A19 Downhill Lane Junction Improvement Project

Section 51 Advice – ‘Early Submission’ of draft application documents by Highways England for PINS review

Drawing Title **LAND TAKE**

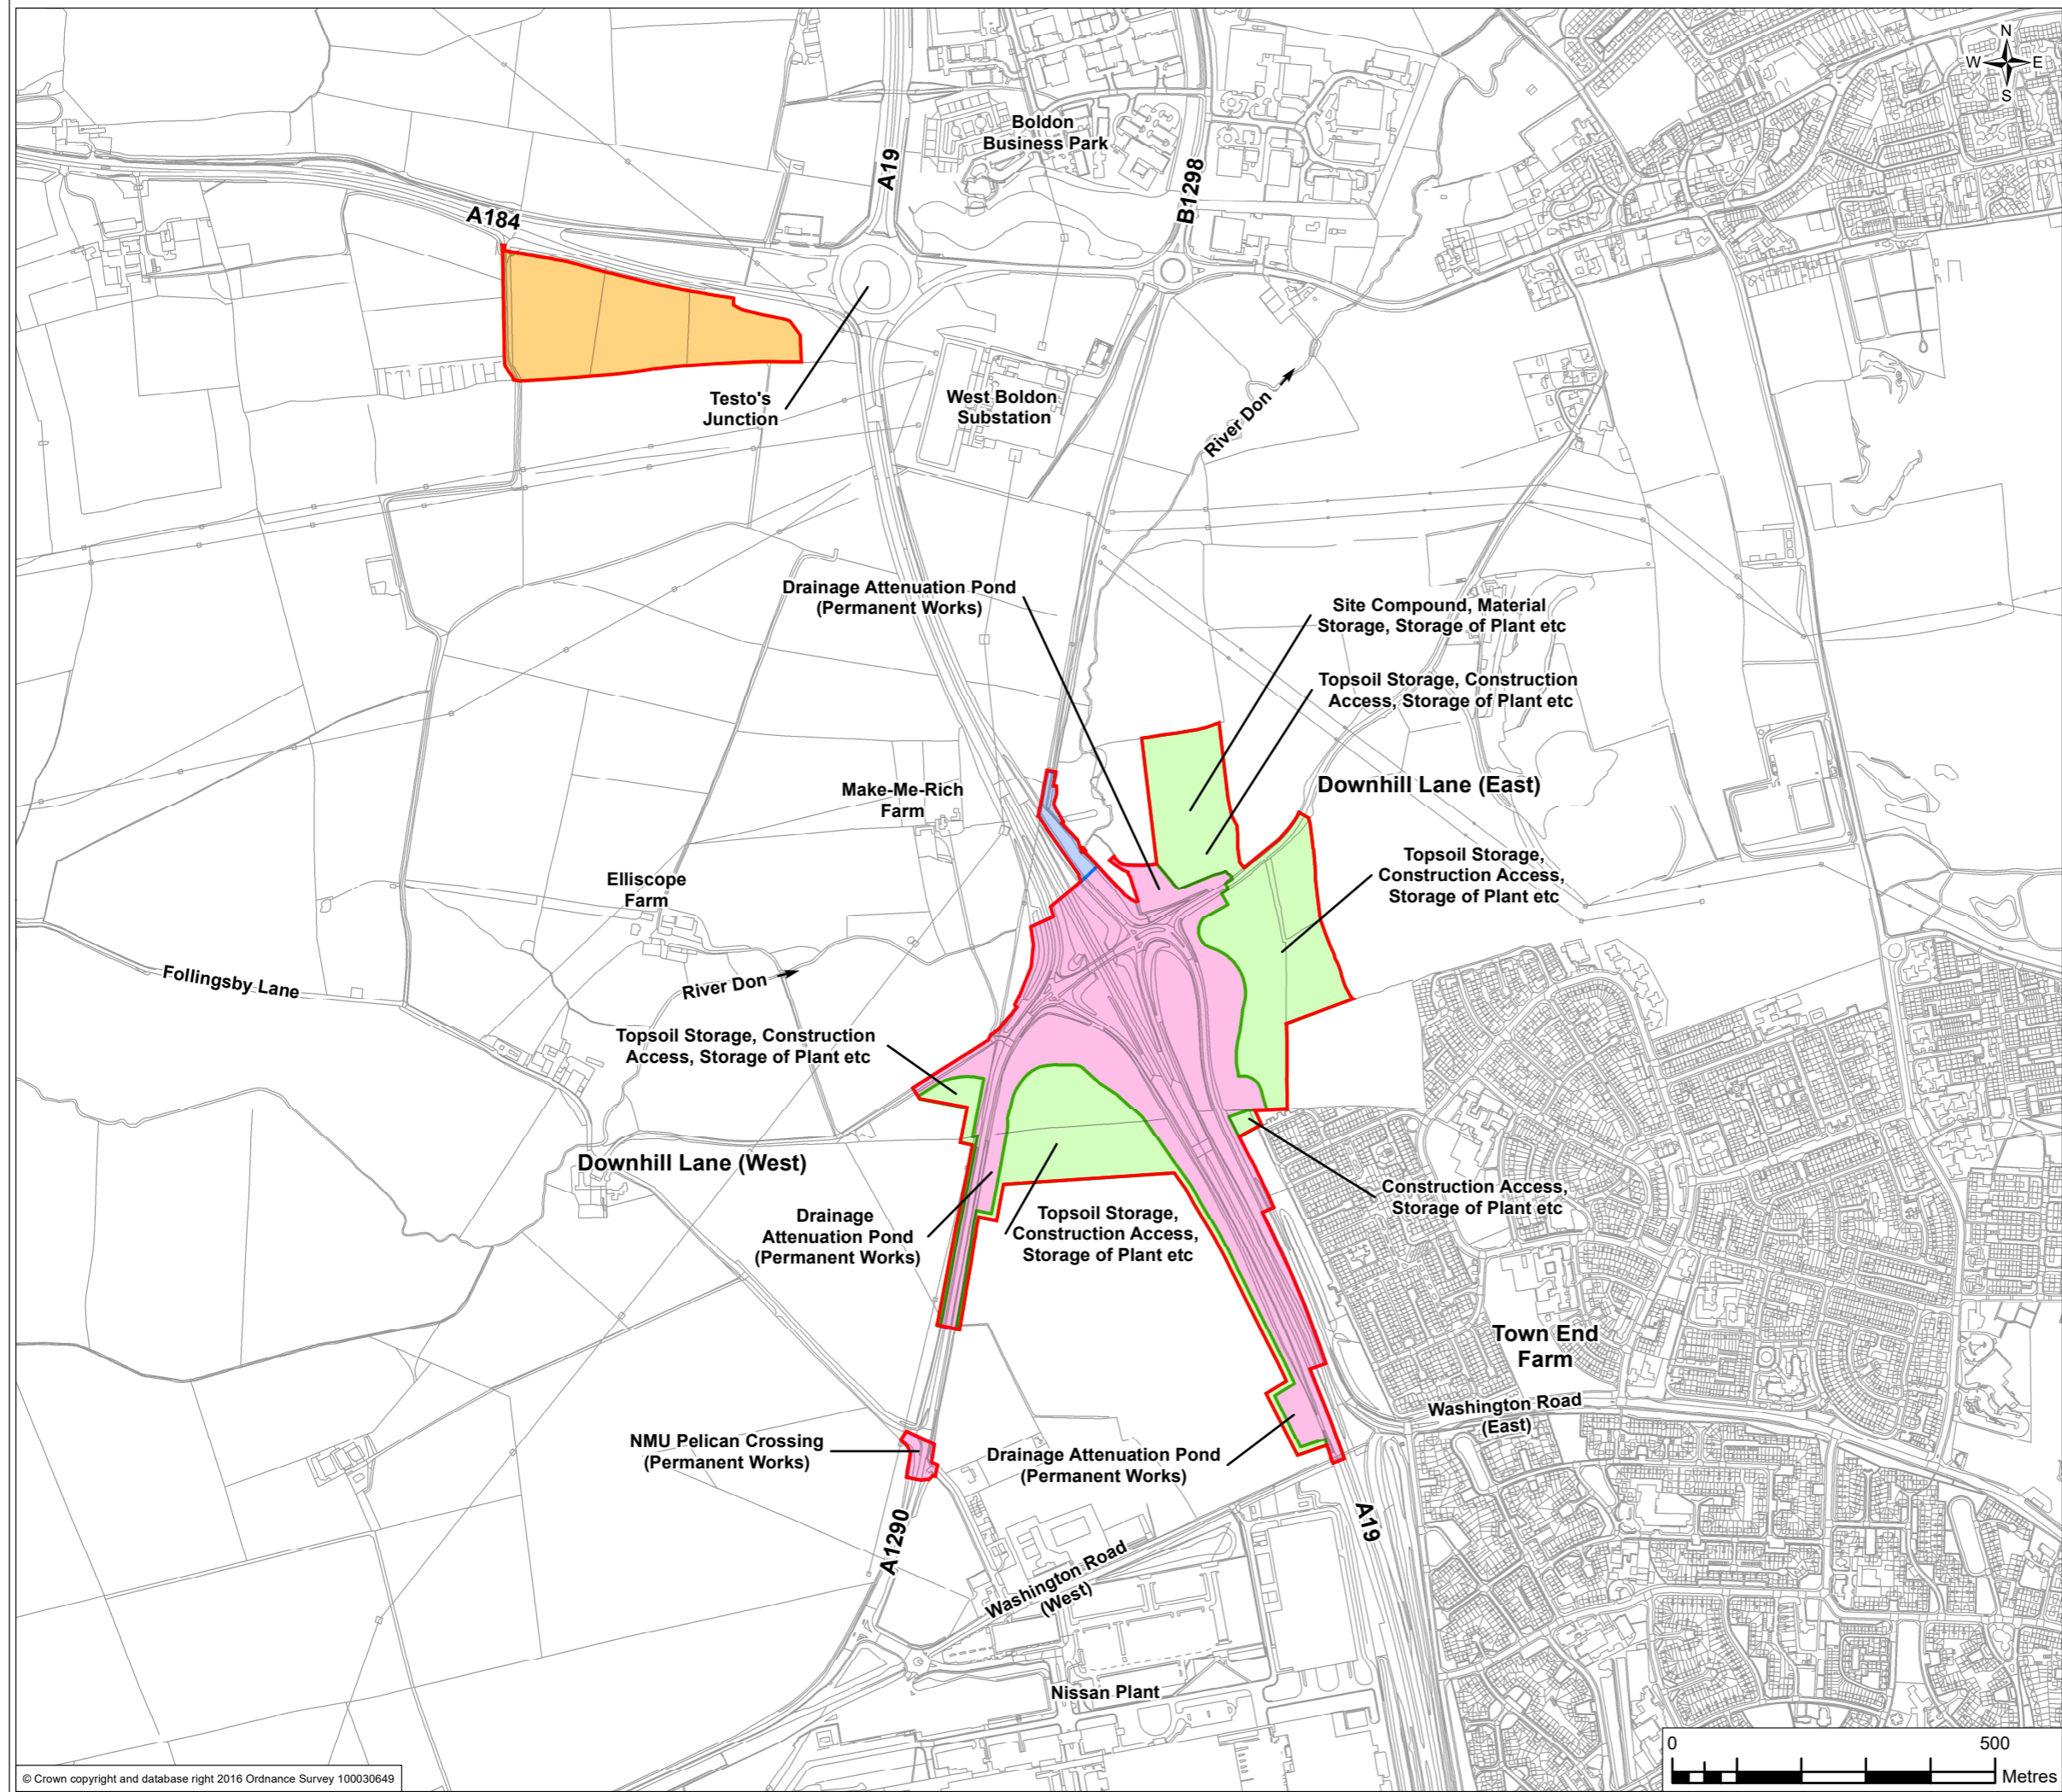
2. The Land plans identify plots marked pink as "*Land to be Acquired or Used permanently for construction, operation and maintenance works*"
 - We assume land to be used permanently means land already in HE ownership.

- Should land subject to CA and land already in HE ownership not be defined separately, either on Lands Plan or within SoR?
 - The key on Land Plan refers to "*Land to be Acquired or Used **permanently** for construction, operation and maintenance works.*"
Confusion in terms of rights being sought for "permanent construction", previous DCO applications e.g. M20 Land Plan key refers to '*Land to be permanently acquired*'.
